Lisa Lindburg
Brandt Design Group
66 Bell Street
Seattle, WA 98121
lisa@brandtdesigninc.com
July 19, 2019

Re: 1907-017

Nicole Gaudette and Paul Skidmore
Community Planning & Development
City of Mercer Island

The Yuan permit set has been revised and we are responding to your intake submittal comments. Below are the itemized changes that are clouded on each sheet as revision 1.

A100

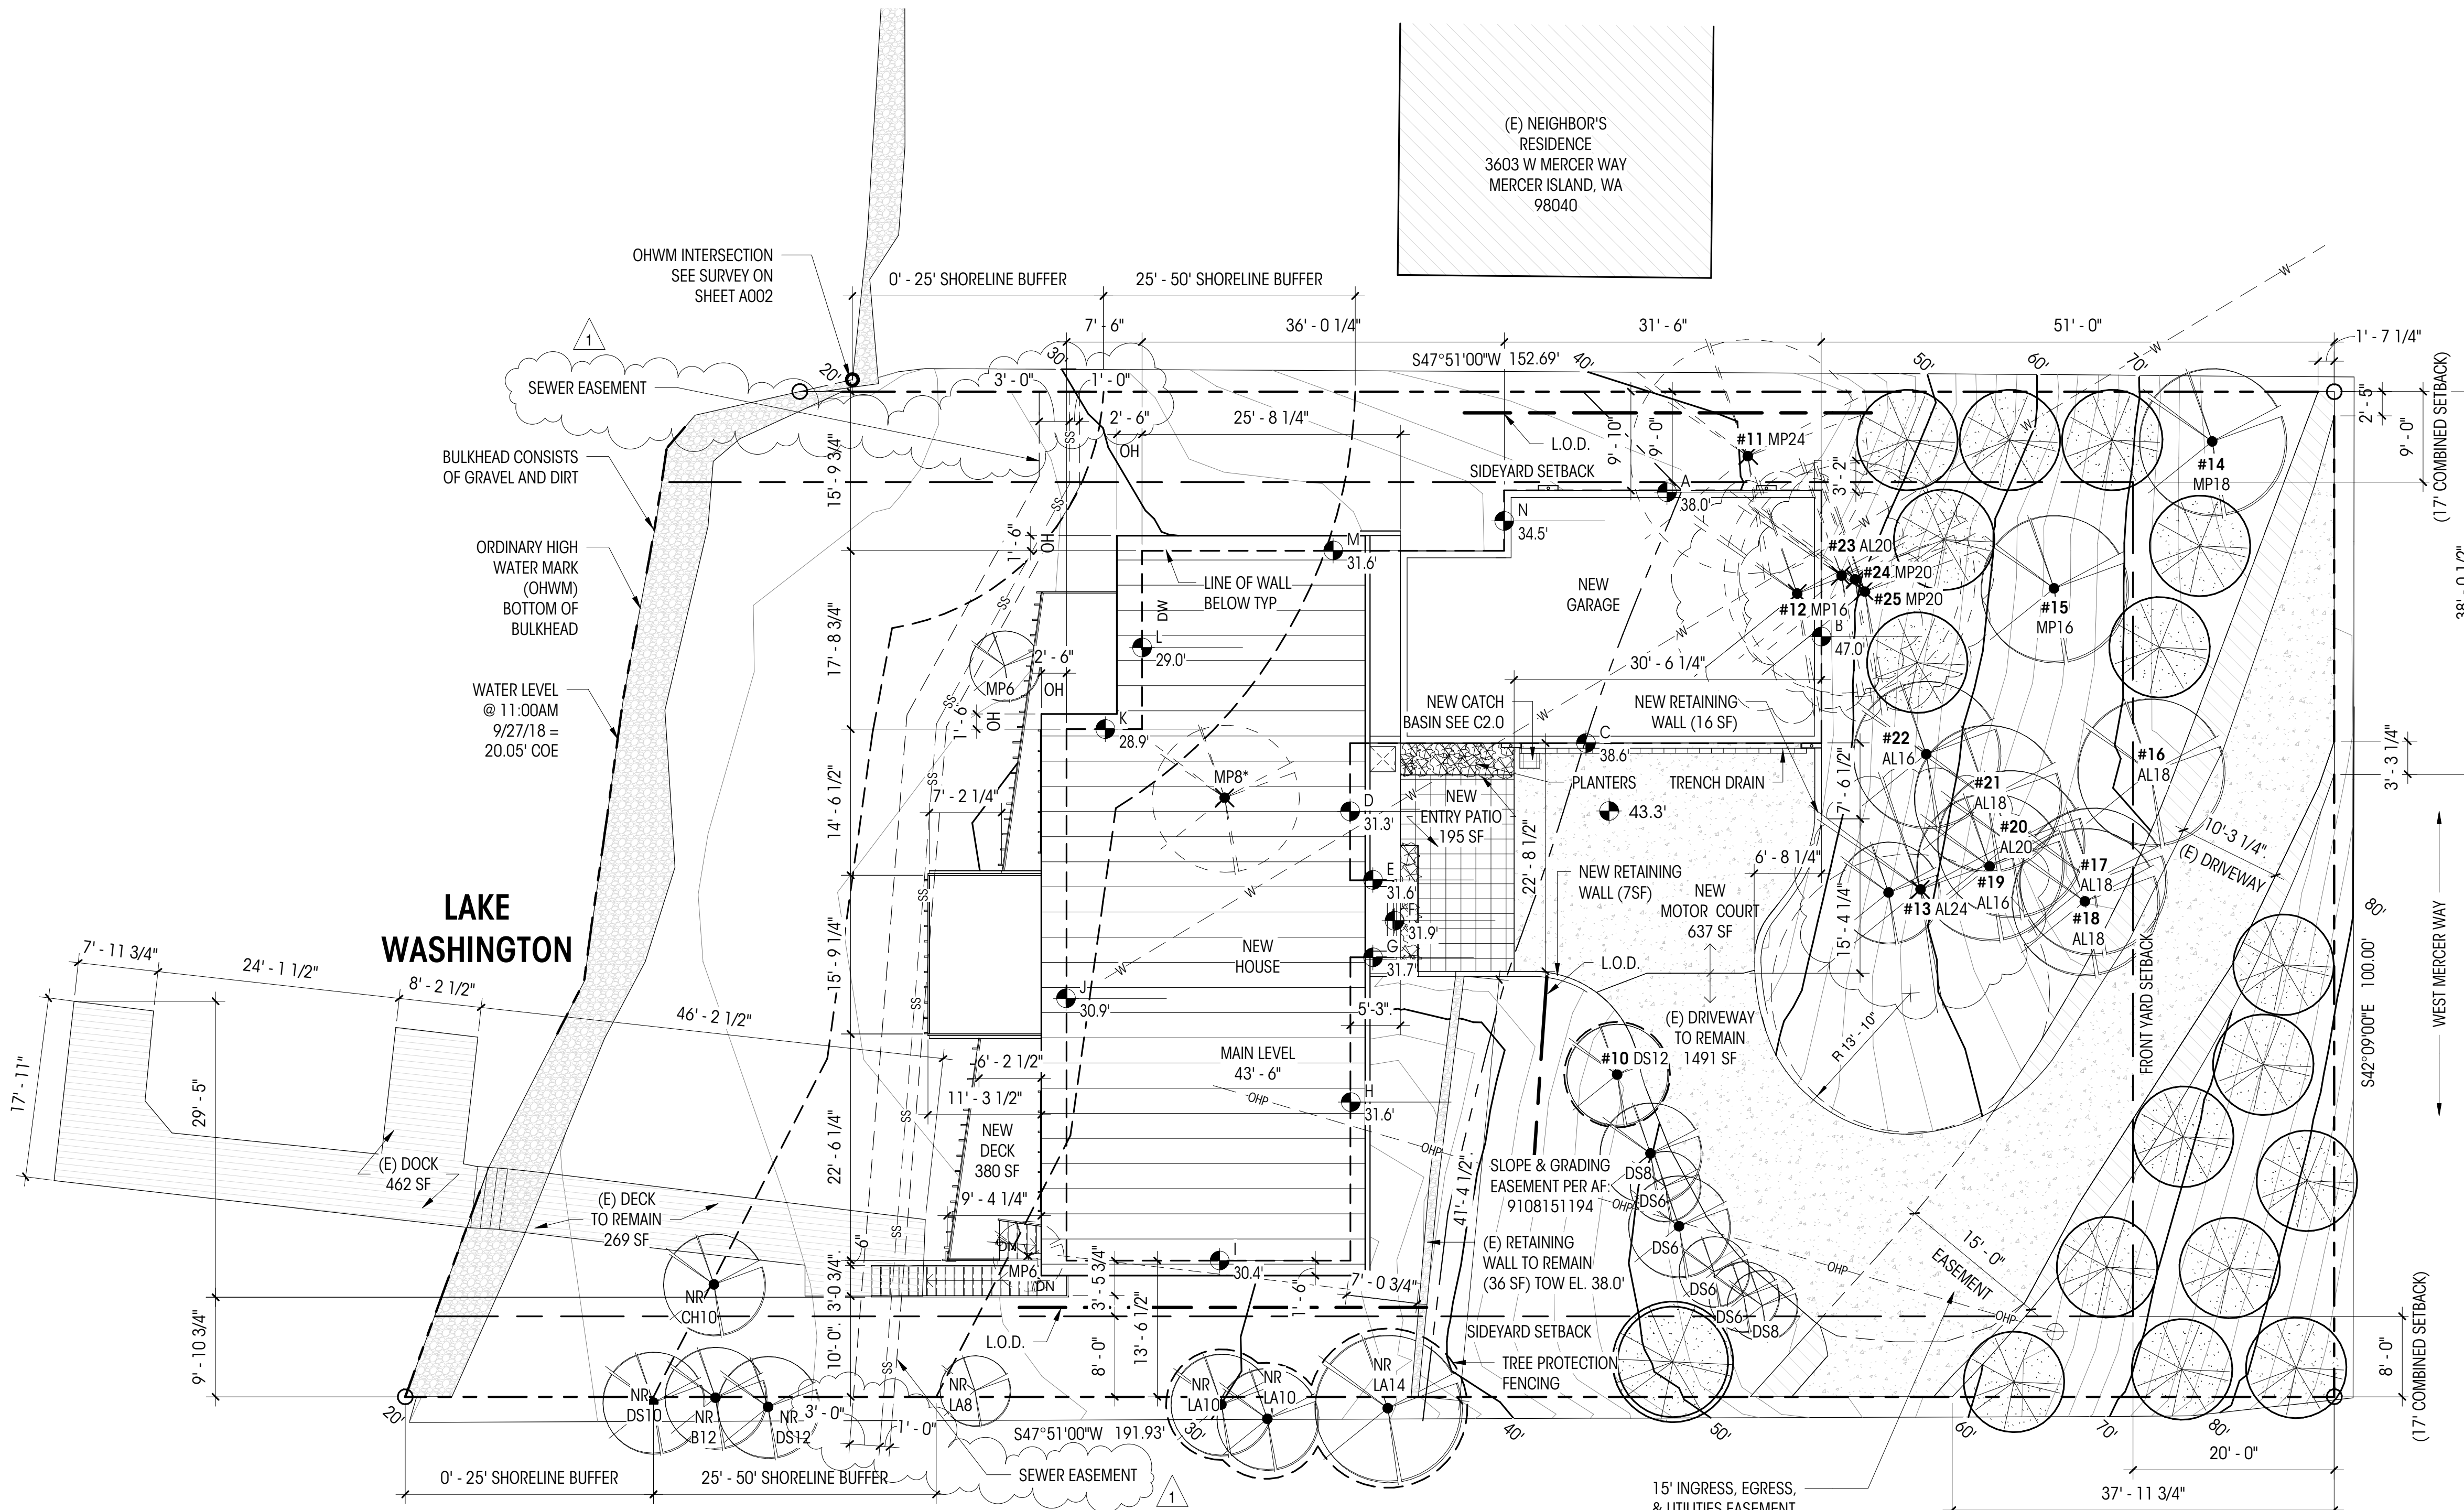
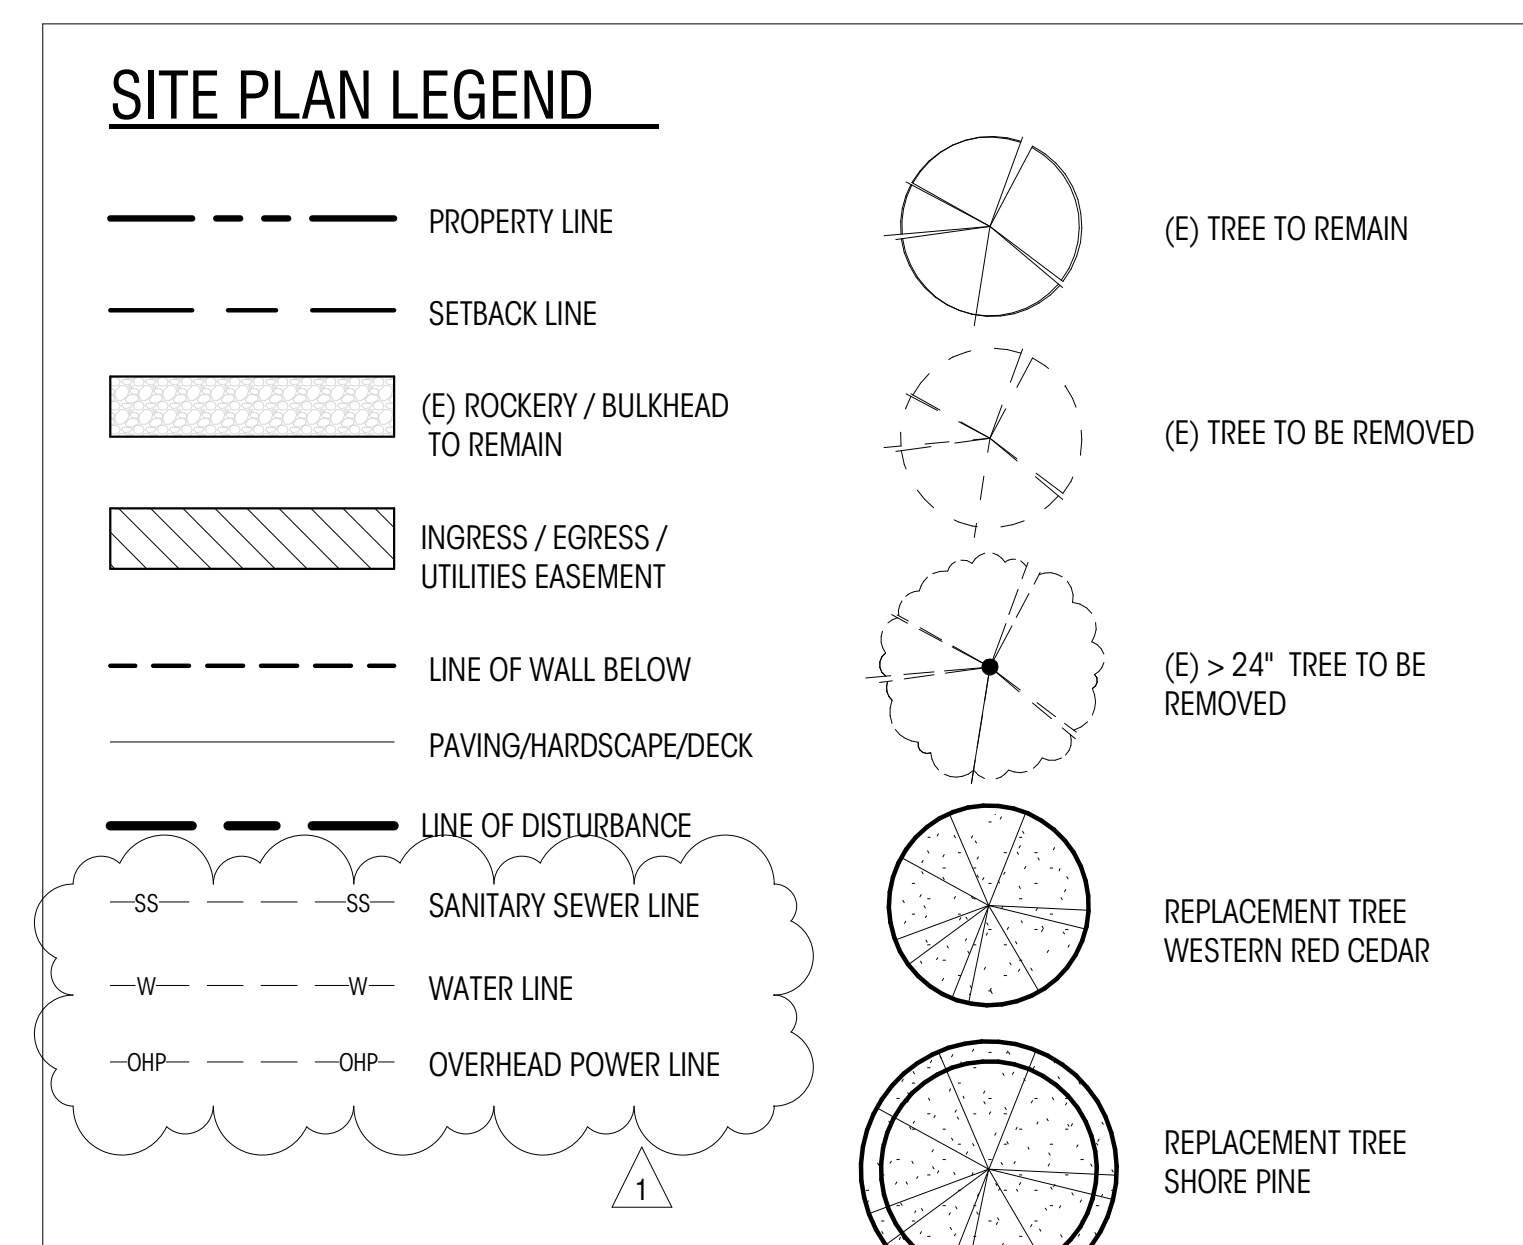
Sheet #	TITLE	REVISION
Sheet A000	Coversheet	1. Revised Lot coverage calculation. The 192 SF deck canopy was mistakenly identified as an “accessory building” and is now included in the overall building SF.
Sheet A100	Site Plan	1. Utilities and utility easements are now shown. These include the sewer easement, overhead power and water. 2. Revised Lot coverage calculation. The 192 SF deck canopy was mistakenly identified as an “accessory building” and is now included in the overall building SF.
Sheet D100	Demo Site Plan	1. Revised Lot coverage calculation. The 192 SF deck canopy was mistakenly identified as an “accessory building” and is now included in the overall building SF.
Sheet 300	Exterior Elevations	Site cut and fill outside of the building footprint is shown.
Sheet 301	Exterior Elevations	Site cut and fill outside of the building footprint is shown.
